AB/120/20/PL & AB/121/20/L

Old Bank House 1 High Street Arundel BN18 9AD

Change of use of existing building from office (Use Class B1a) to residential dwelling (Use Class C3) with minor internal layout changes. This application affects the setting of listed buildings, affects the character & appearance of the Arundel Conservation Area

Project:- Old Bank House 1 High Street Arundel West Sussex			
Title:- Proposed Floor Plans			
Client:- Moor Construction Ltd			
Scale:- 1:50 (@A1)			
Drawn By:- PJD	Checked By:-		
Date:- 10/11/20	Date:-		
Job.No:- 200042	Drg.No:-	Rev:- 06

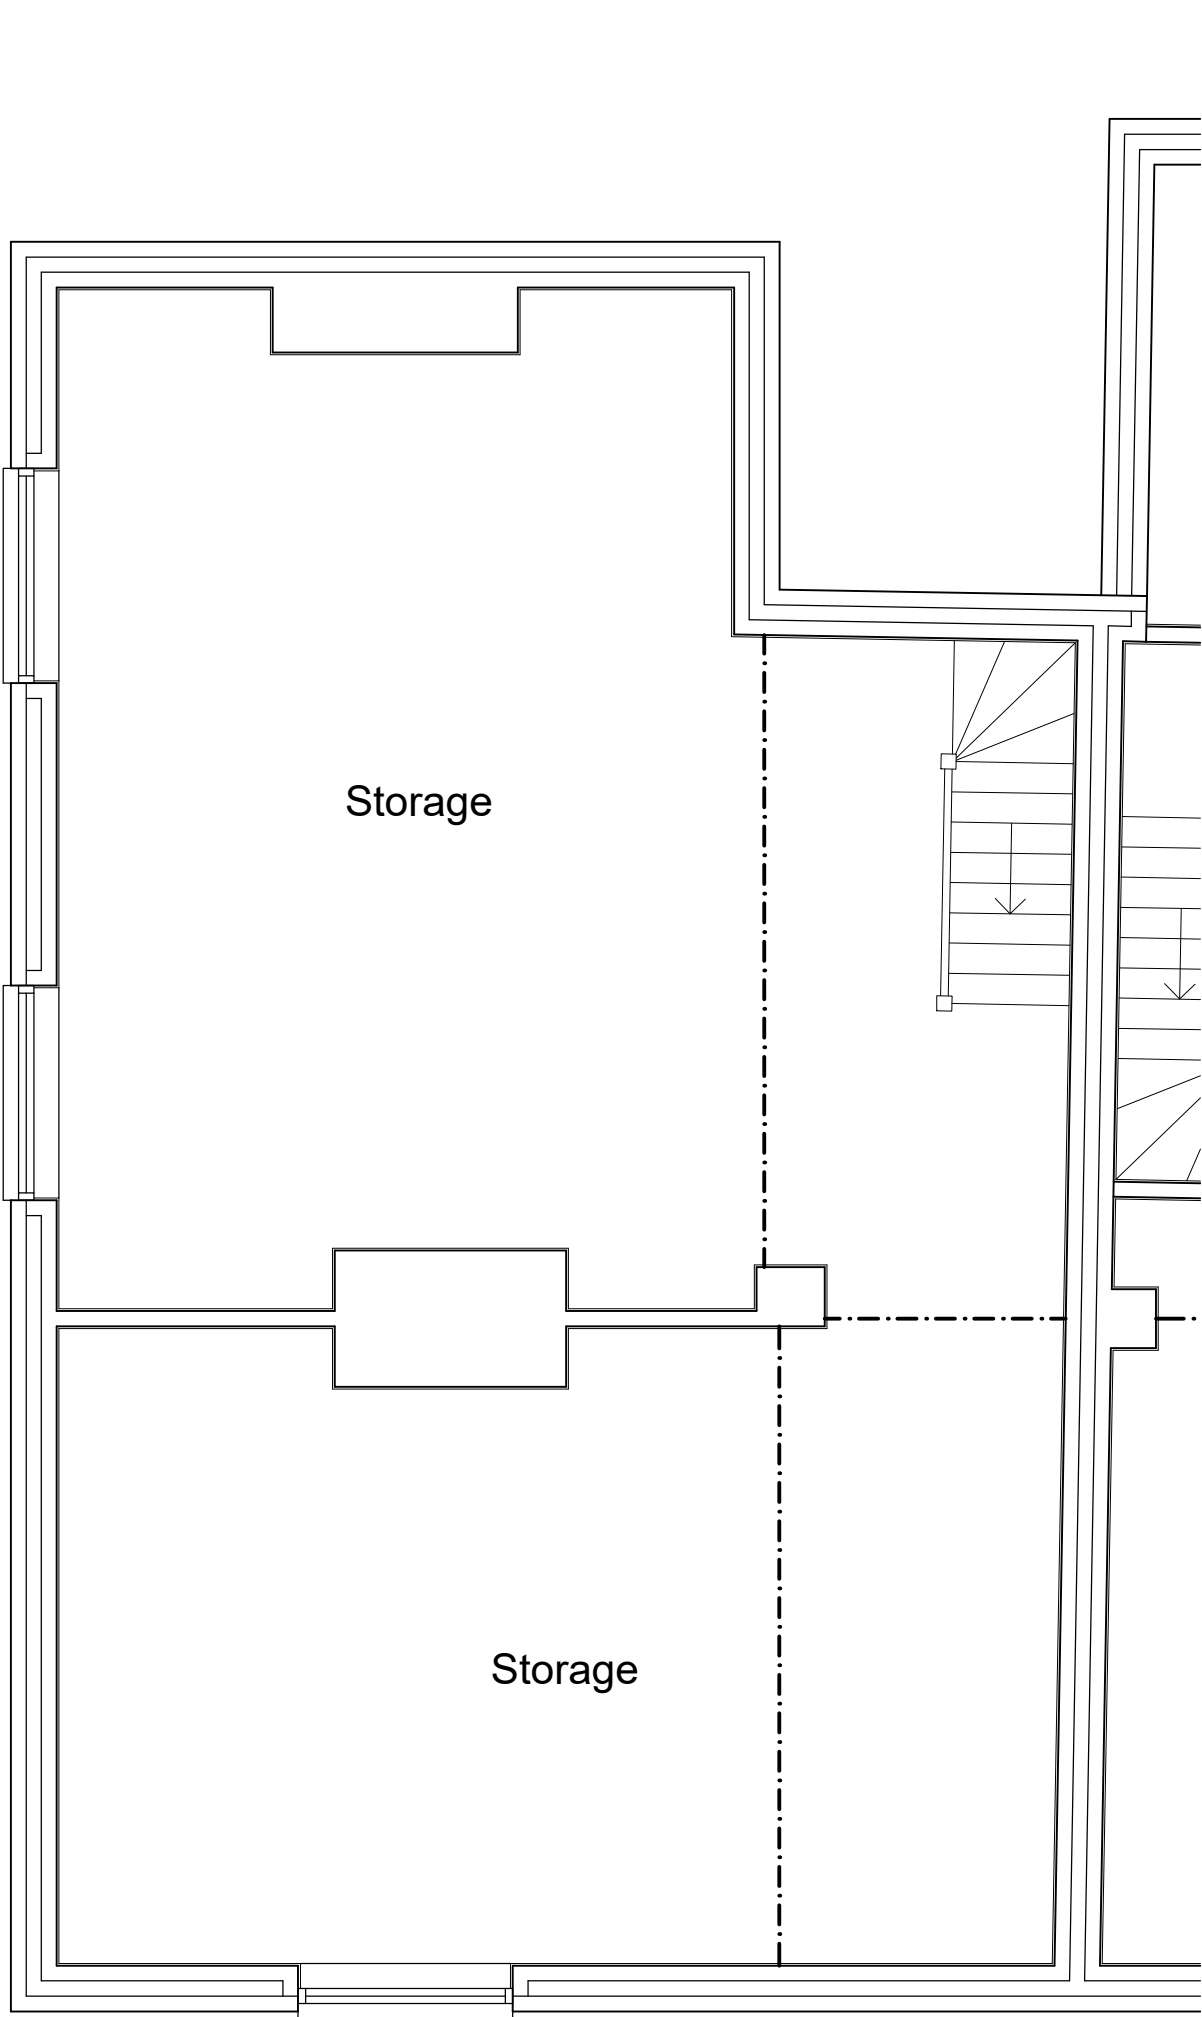
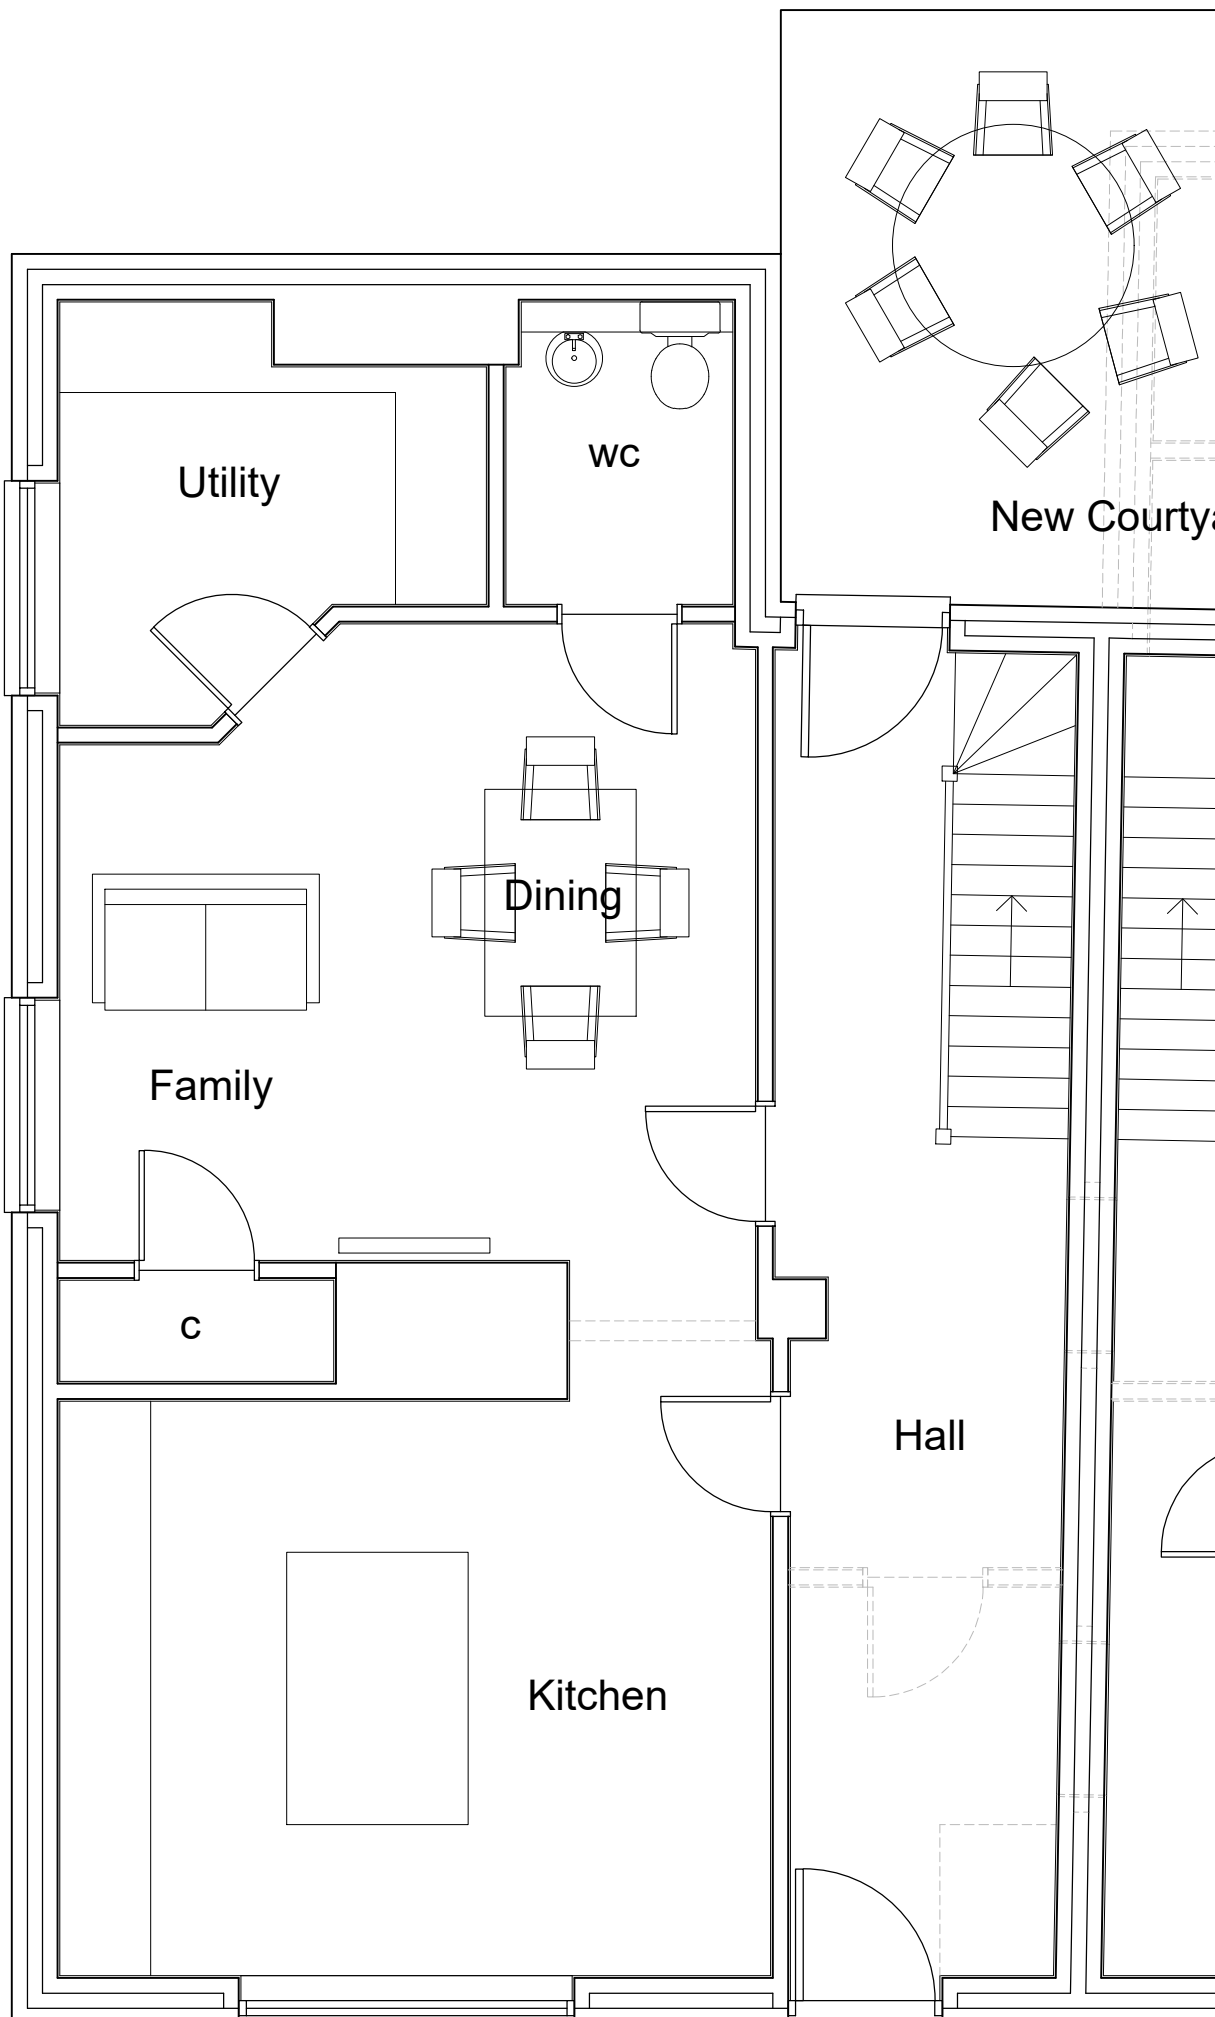
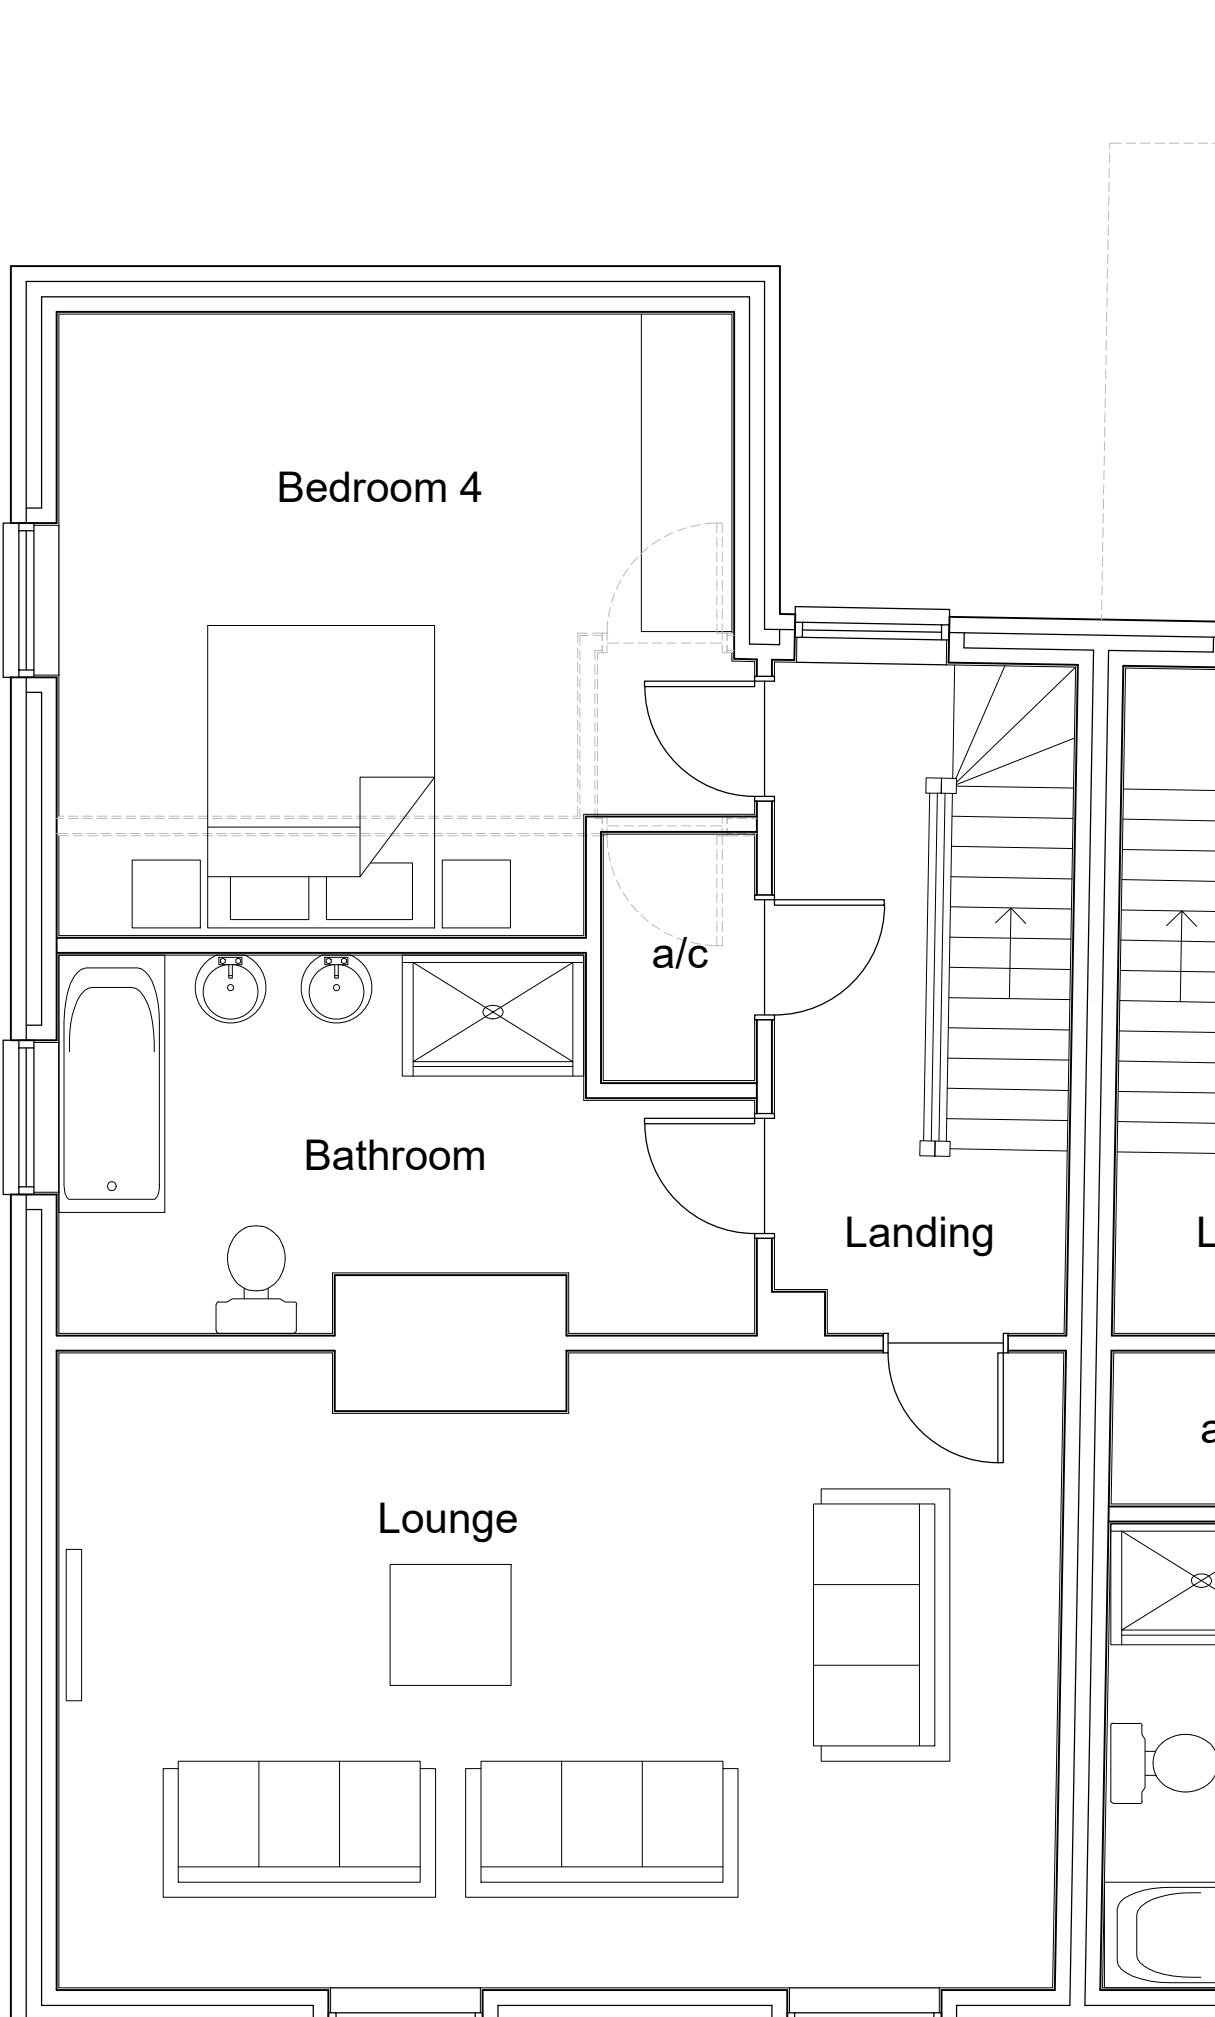
When reviewing the plans provided it is clear that a number of internal alterations are required including the relocation of walling and the introduction of new kitchen and bathroom facilities. Reference is also made to the fact that there has been a considerable amount of modernisation to the interior of the building, including the introduction of fire doors. It is not clear if these fire doors are to be replaced, and if they are, what with? The loss of modern material is acceptable, especially if it is to be replaced with something more in keeping with the age and style of the building. Details of the internal joinery such as doors and skirting boards etc. could be provided for by way of condition, if you are minded to approve the application. The relocation of some internal walls are of a scale which will not harm the significance of the building.

The introduction of new bathrooms and kitchen would be into rooms currently used as offices and will require the introduction of new plumbing/electrics into these spaces. It is not clear how the drainage will be dealt with from these new rooms. It should not be via the elevations which present themselves to the public domain. Likewise, care must be taken when installing new pipework and cables so that limited historic fabric is lost.
